From:
Sent: 15 August 2023 14:36
To: DCAdmin
Subject: Comment on Application number 2023/62/91280/E0 (over word limit)

As a resident of Upper Cumberworth, I am writing to express my serious concerns about the application submitted to restart mineral extraction at Bromley Farm Quarry after nearly a decade. This application contains significant inconsistencies and misleading statements that may have deceived some of those who were consulted as part of the statutory requirement. These concerns revolve around traffic issues, the impact on the environment and noise, and the overall environmental implications. Even though the area is designated for possible mineral extraction in Kirklees, the application fails to adequately justify why this location should be chosen or what safeguards will be implemented for the community.

REV	DATE	DESCRIPTION
PROJECT		
BROMLEY FARM QUARRY, UPPER CUMBERWORTH		
TITLE		
ACCESS PROPOSALS		
SCALE		
1:250 @ A1		
DRAWING		
2074-101		
DATE		
12.04.2022		
DRAWN	CHECKED	ALTERED
CH	AH	-

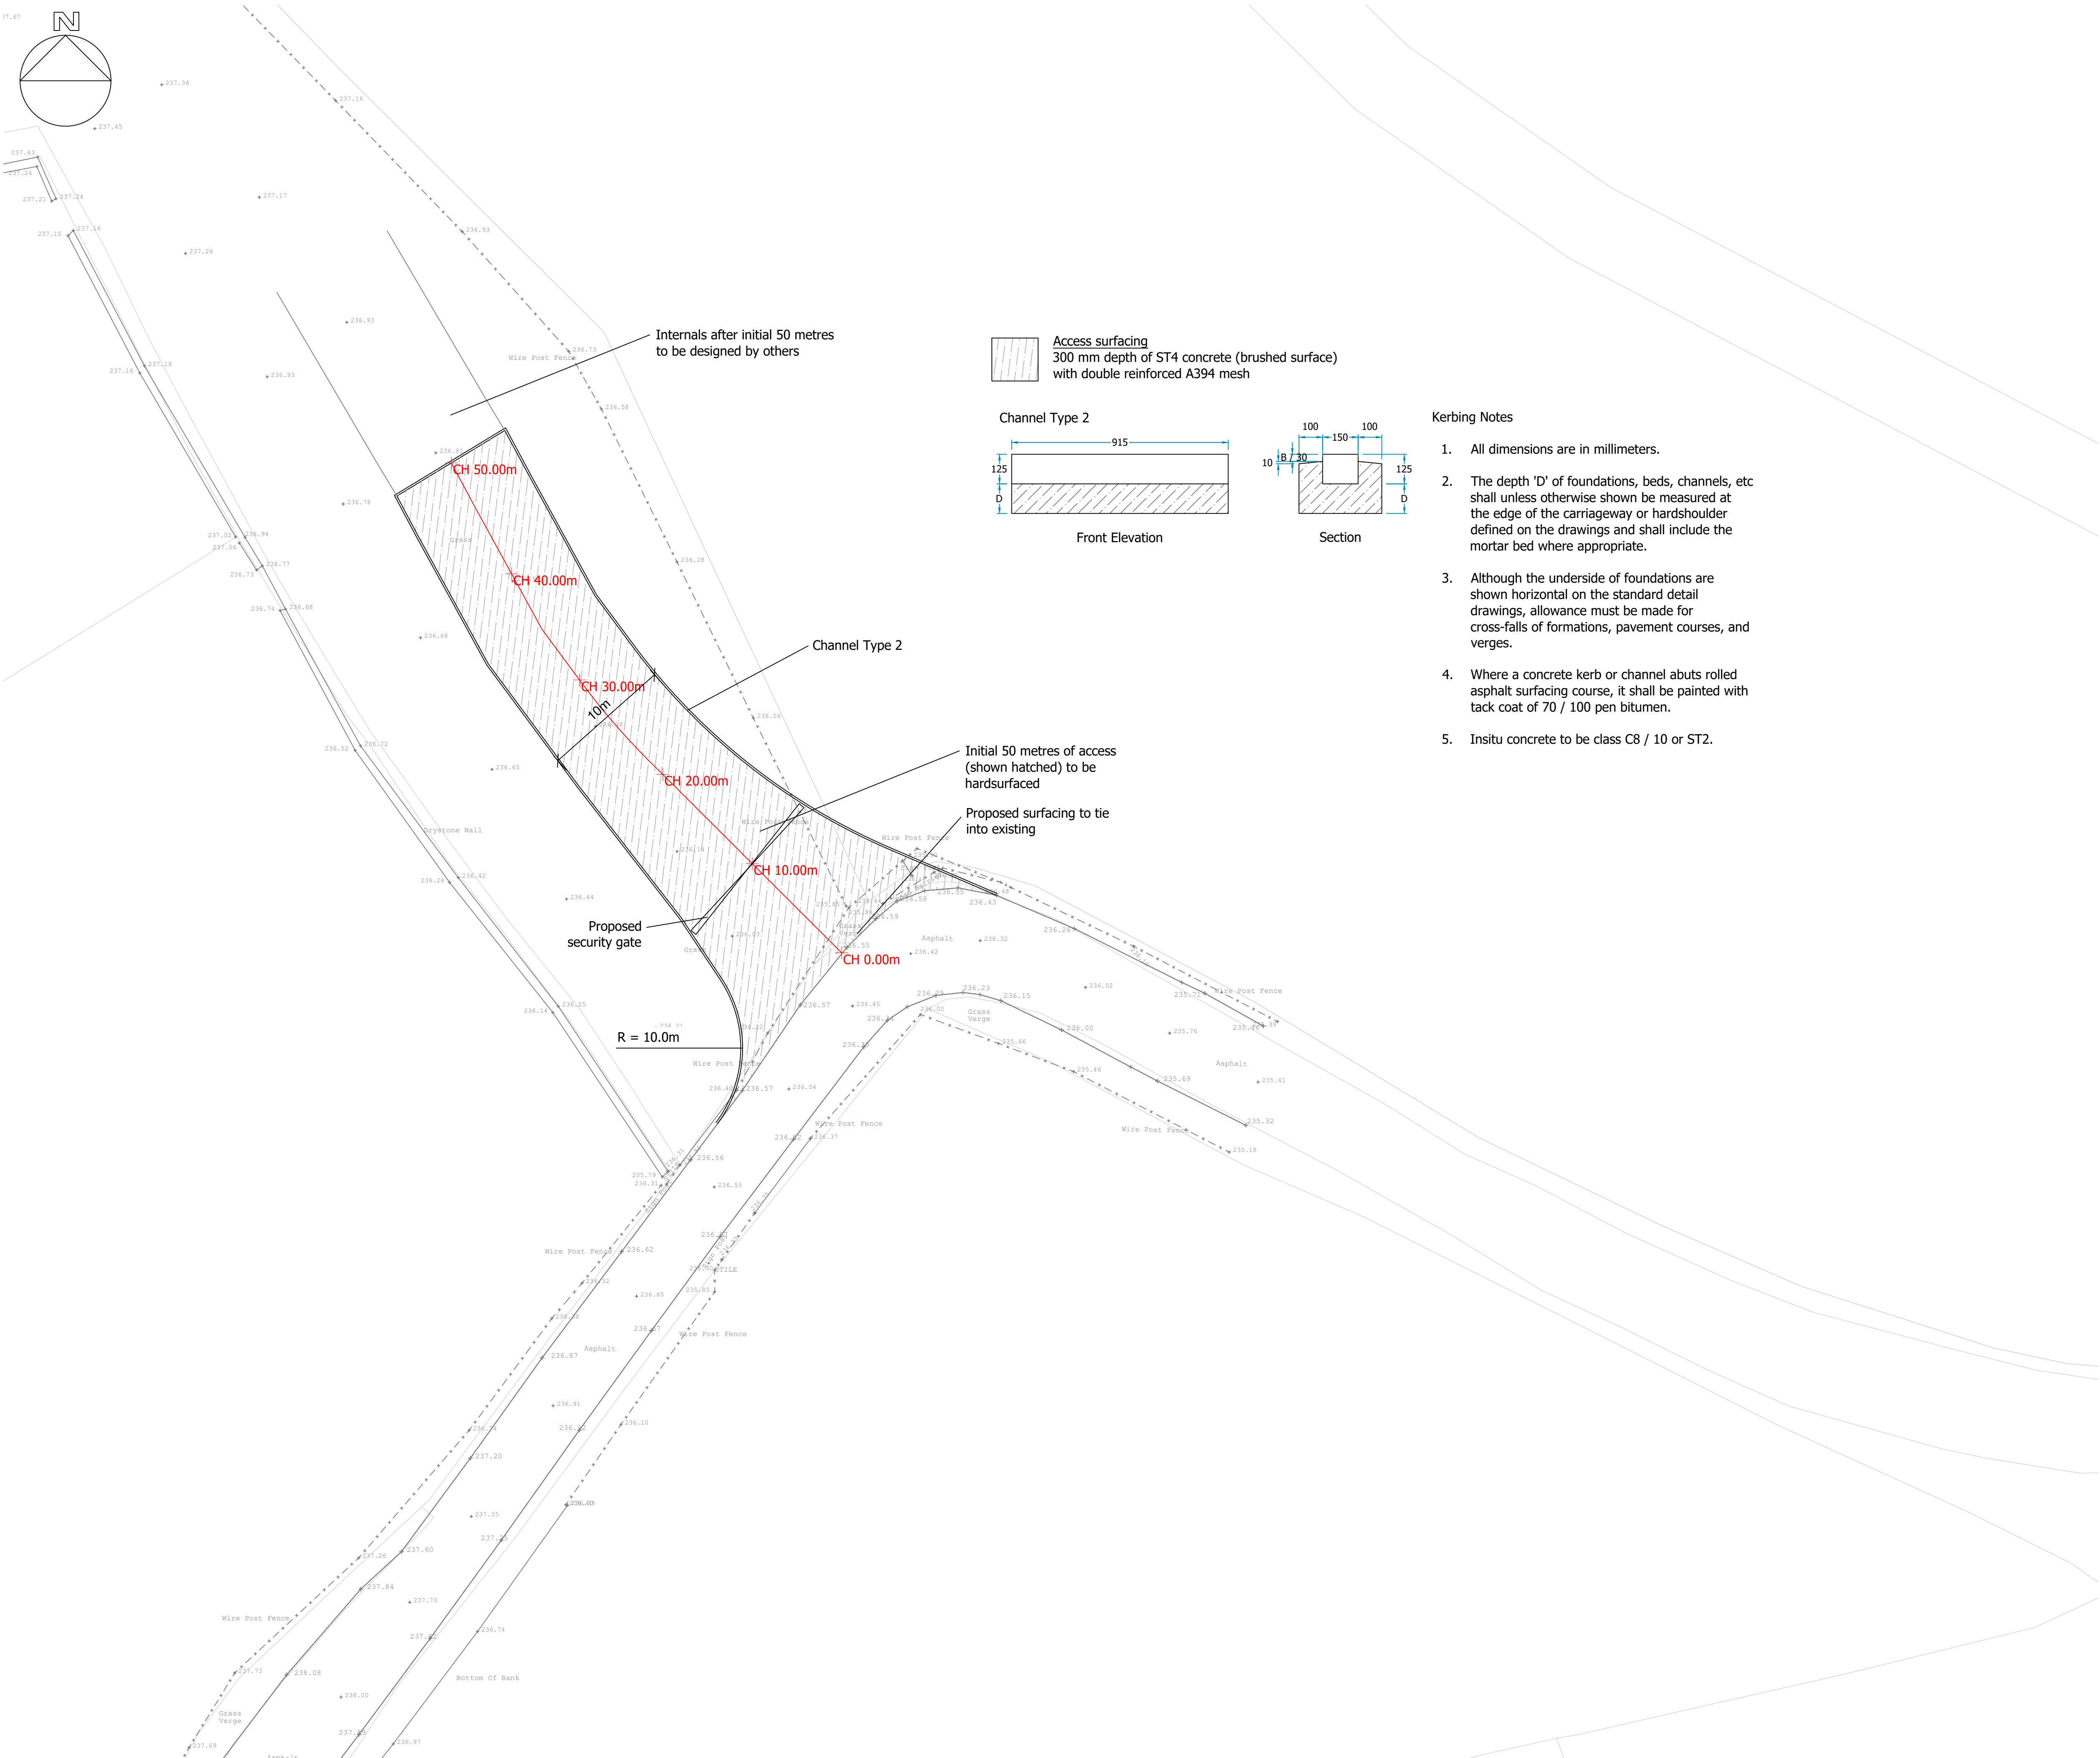
— The Access Road plans provided by Paragon Highways (ID 987937) depict a single lane off Barnsley Road (A635), which contradicts the claim of two lanes elsewhere. Although the new access road is shown with two lanes, HGVs from the quarry only use the road towards the tip (which is a deadend) as they exit from it. While this could be an inadvertent error, it remains significantly misleading and makes the situation look much better than the reality of HGVs needing to pass on the already busy recycling centre approach. If the company, which should have an intimate understanding of traffic and vehicle requirements, cannot accurately present this detail (unless intentionally misleading), it raises concerns about their competence in

other areas as well. The tendency or decision not to show it drawn correctly also highlights the inadequacy of the existing access road, which is narrow and busy (the drawing wouldn't fit!), especially considering the high volume of traffic that would be generated by the proposed operations.
